**KIRKLEES METROPOLITAN COUNCIL  
INVESTMENT & REGENERATION SERVICE**

| Reference No:         | <b>2025/62/91545/E</b>                                |
| Site Address:         | 43, Tanhouse Street, Ravensthorpe, Dewsbury, WF13 3ES |
| Description:          | Erection of single storey rear extension              |

PROPOSED REAR ELEVATION

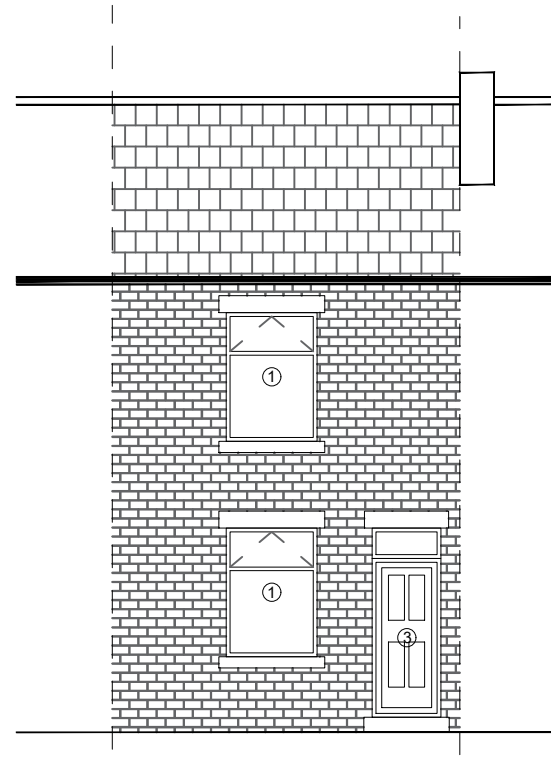
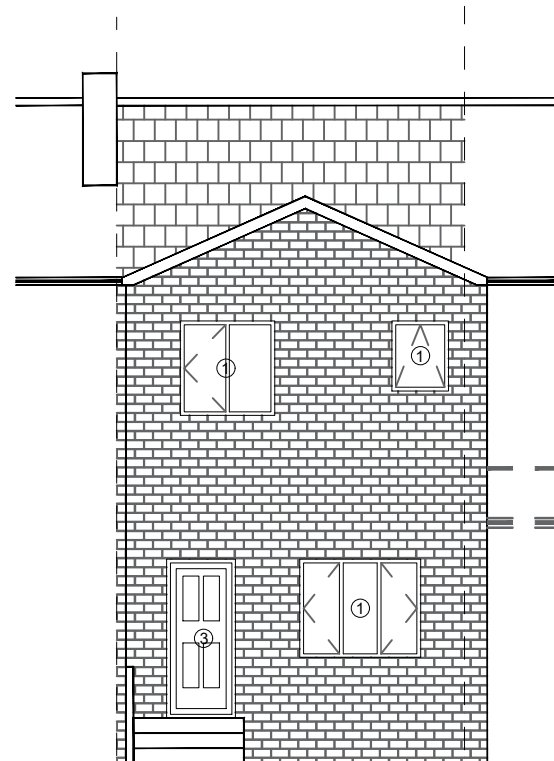
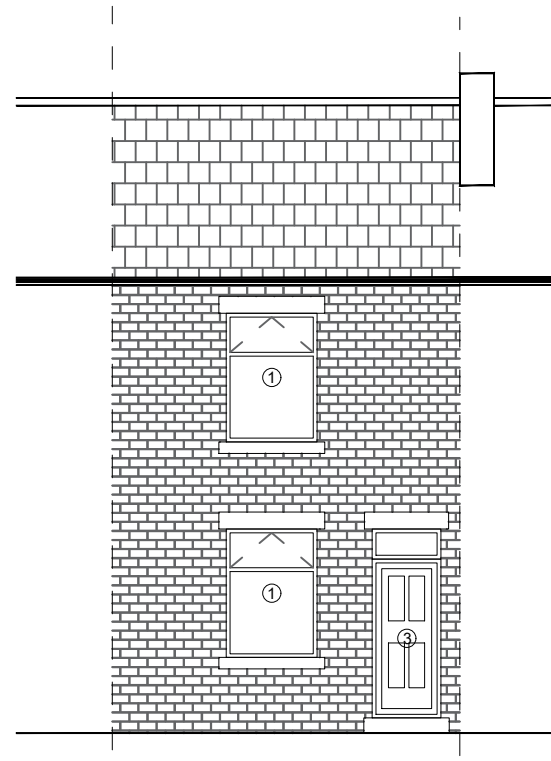
The extension would project an additional 3 metres to the already extended property, resulting in a 6 metre projection along the boundary located to the south of the adjoining property. This would result in additional overshadowing in the afternoon together with an overbearing impact due to the resulting projection. It is noted that the windows in the rear elevation would look into the applicants own amenity space with limited potential to result in overlooking of neighbouring spaces.

The proposed rear extension, by reason of its additional projection along the shared boundary with the adjoining 45 Tanhouse Street would result in overbearing in the afternoon and an overbearing impact of the amenity space and rear windows. To permit the proposals would be contrary to Policy LP24 of the Kirklees Local Plan, KDP 5 & KDP6 of the House Extension & Alteration SPD and Chapter 12 of the National Planning Policy Framework.
